**Consultation Response from KC,
Highways Development Management**

2024/92497 42A, Station Road, Fenay Bridge, Huddersfield, HD8 0AD

Variation of condition 2 (plans list) on previous permission 2020/93329 (erection of one dwelling and associated works) to increase the finished floor levels and overall ridge height of the dwelling, amend the internal layout and to include a garage

Proposed Garage
Grounds of 42a Station Road
Fenay Bridge HD8 0AD

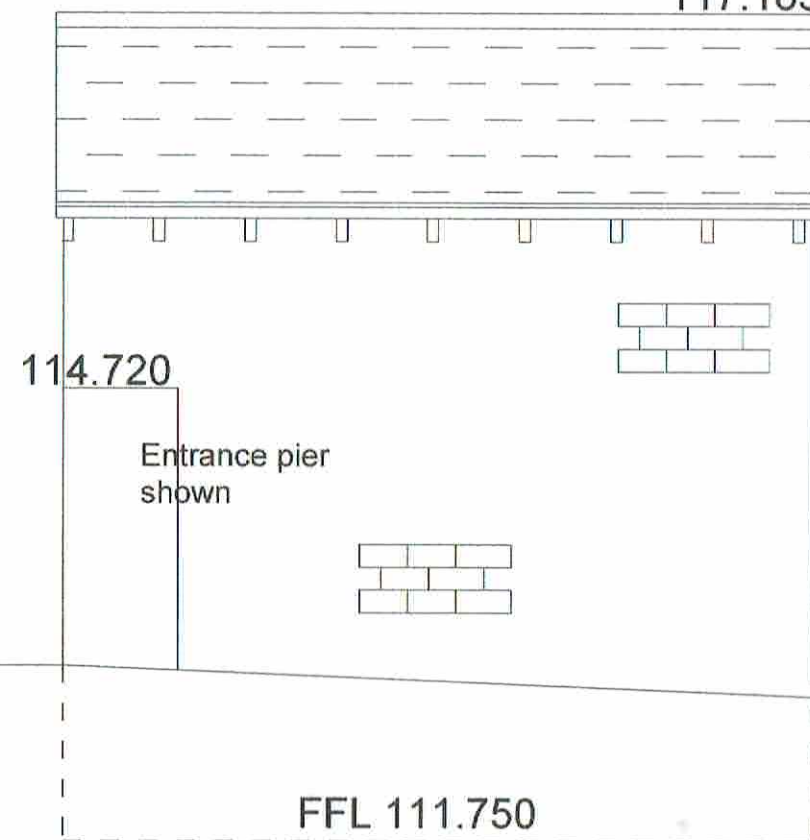
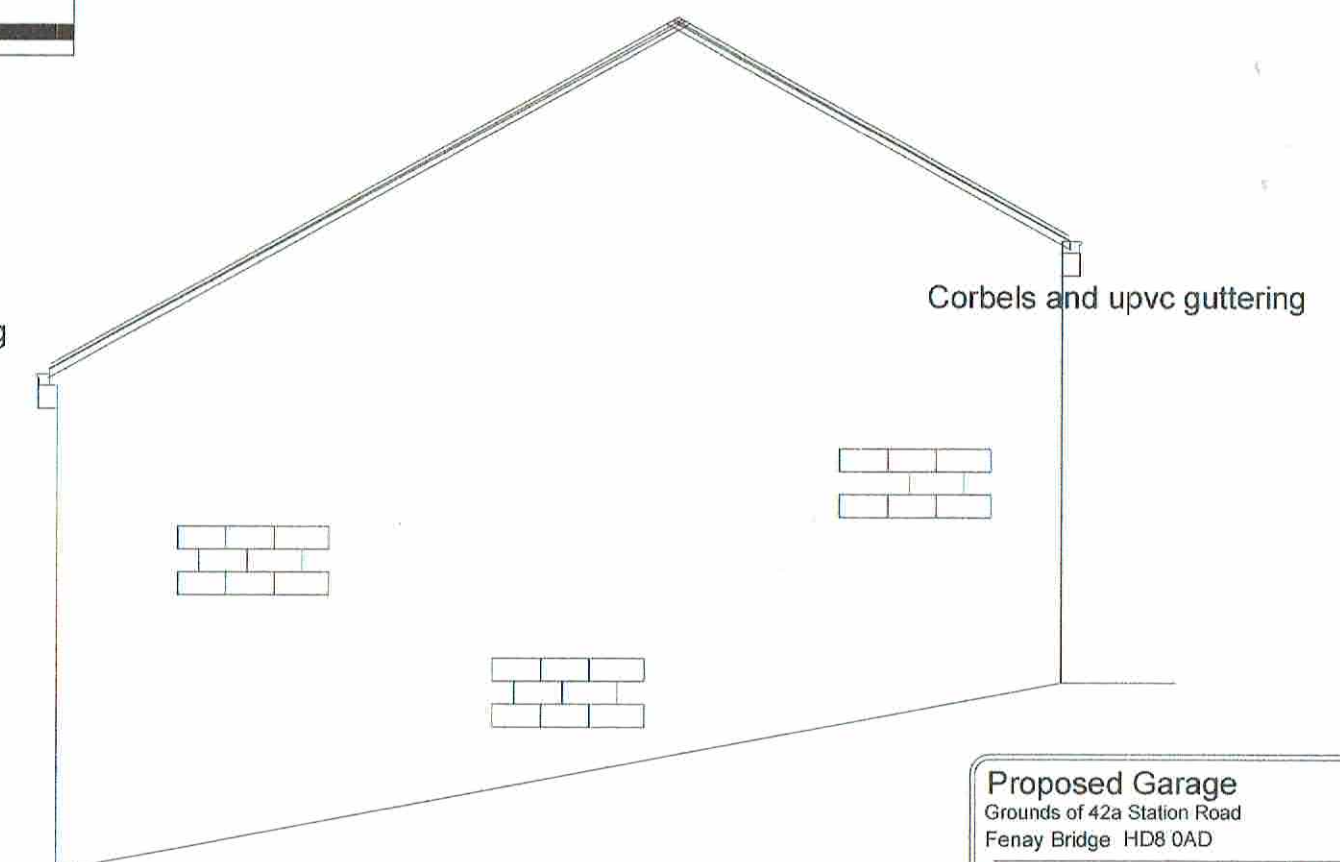
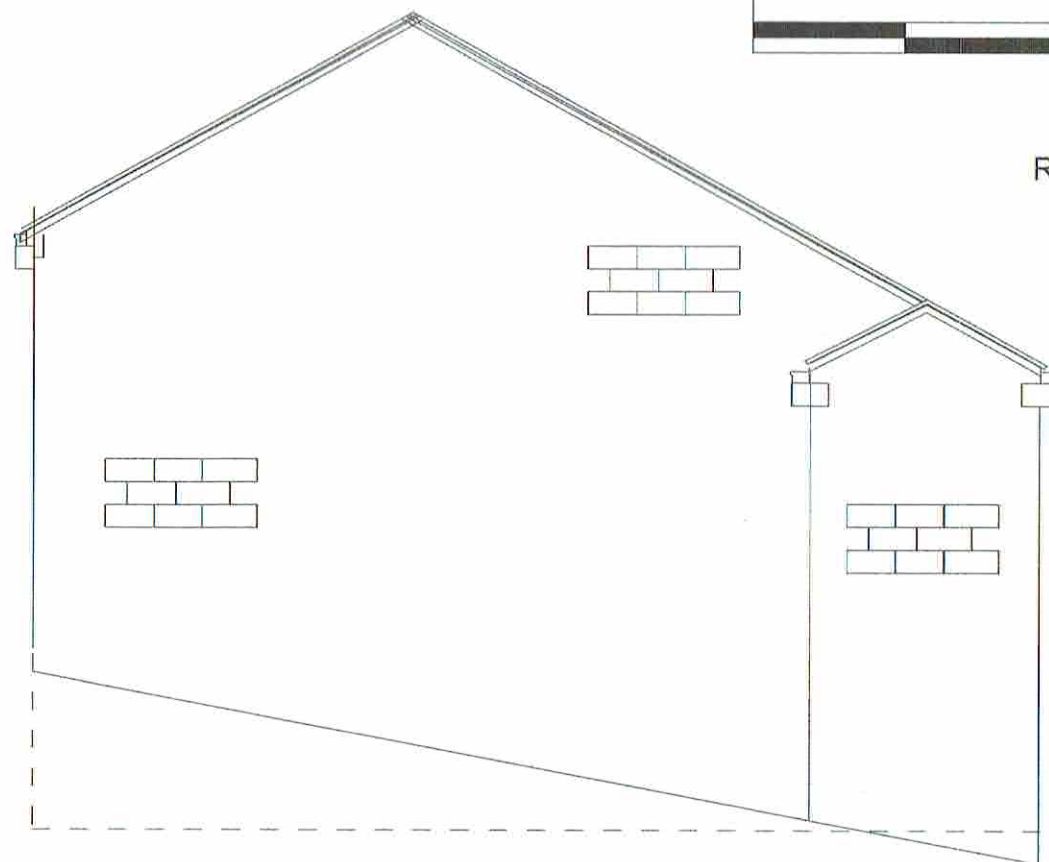
The turning area in front of the proposed garage is narrow and needs to be widened.

The location of the proposed bin storage area will obstruct access to the parking in front of the garage.
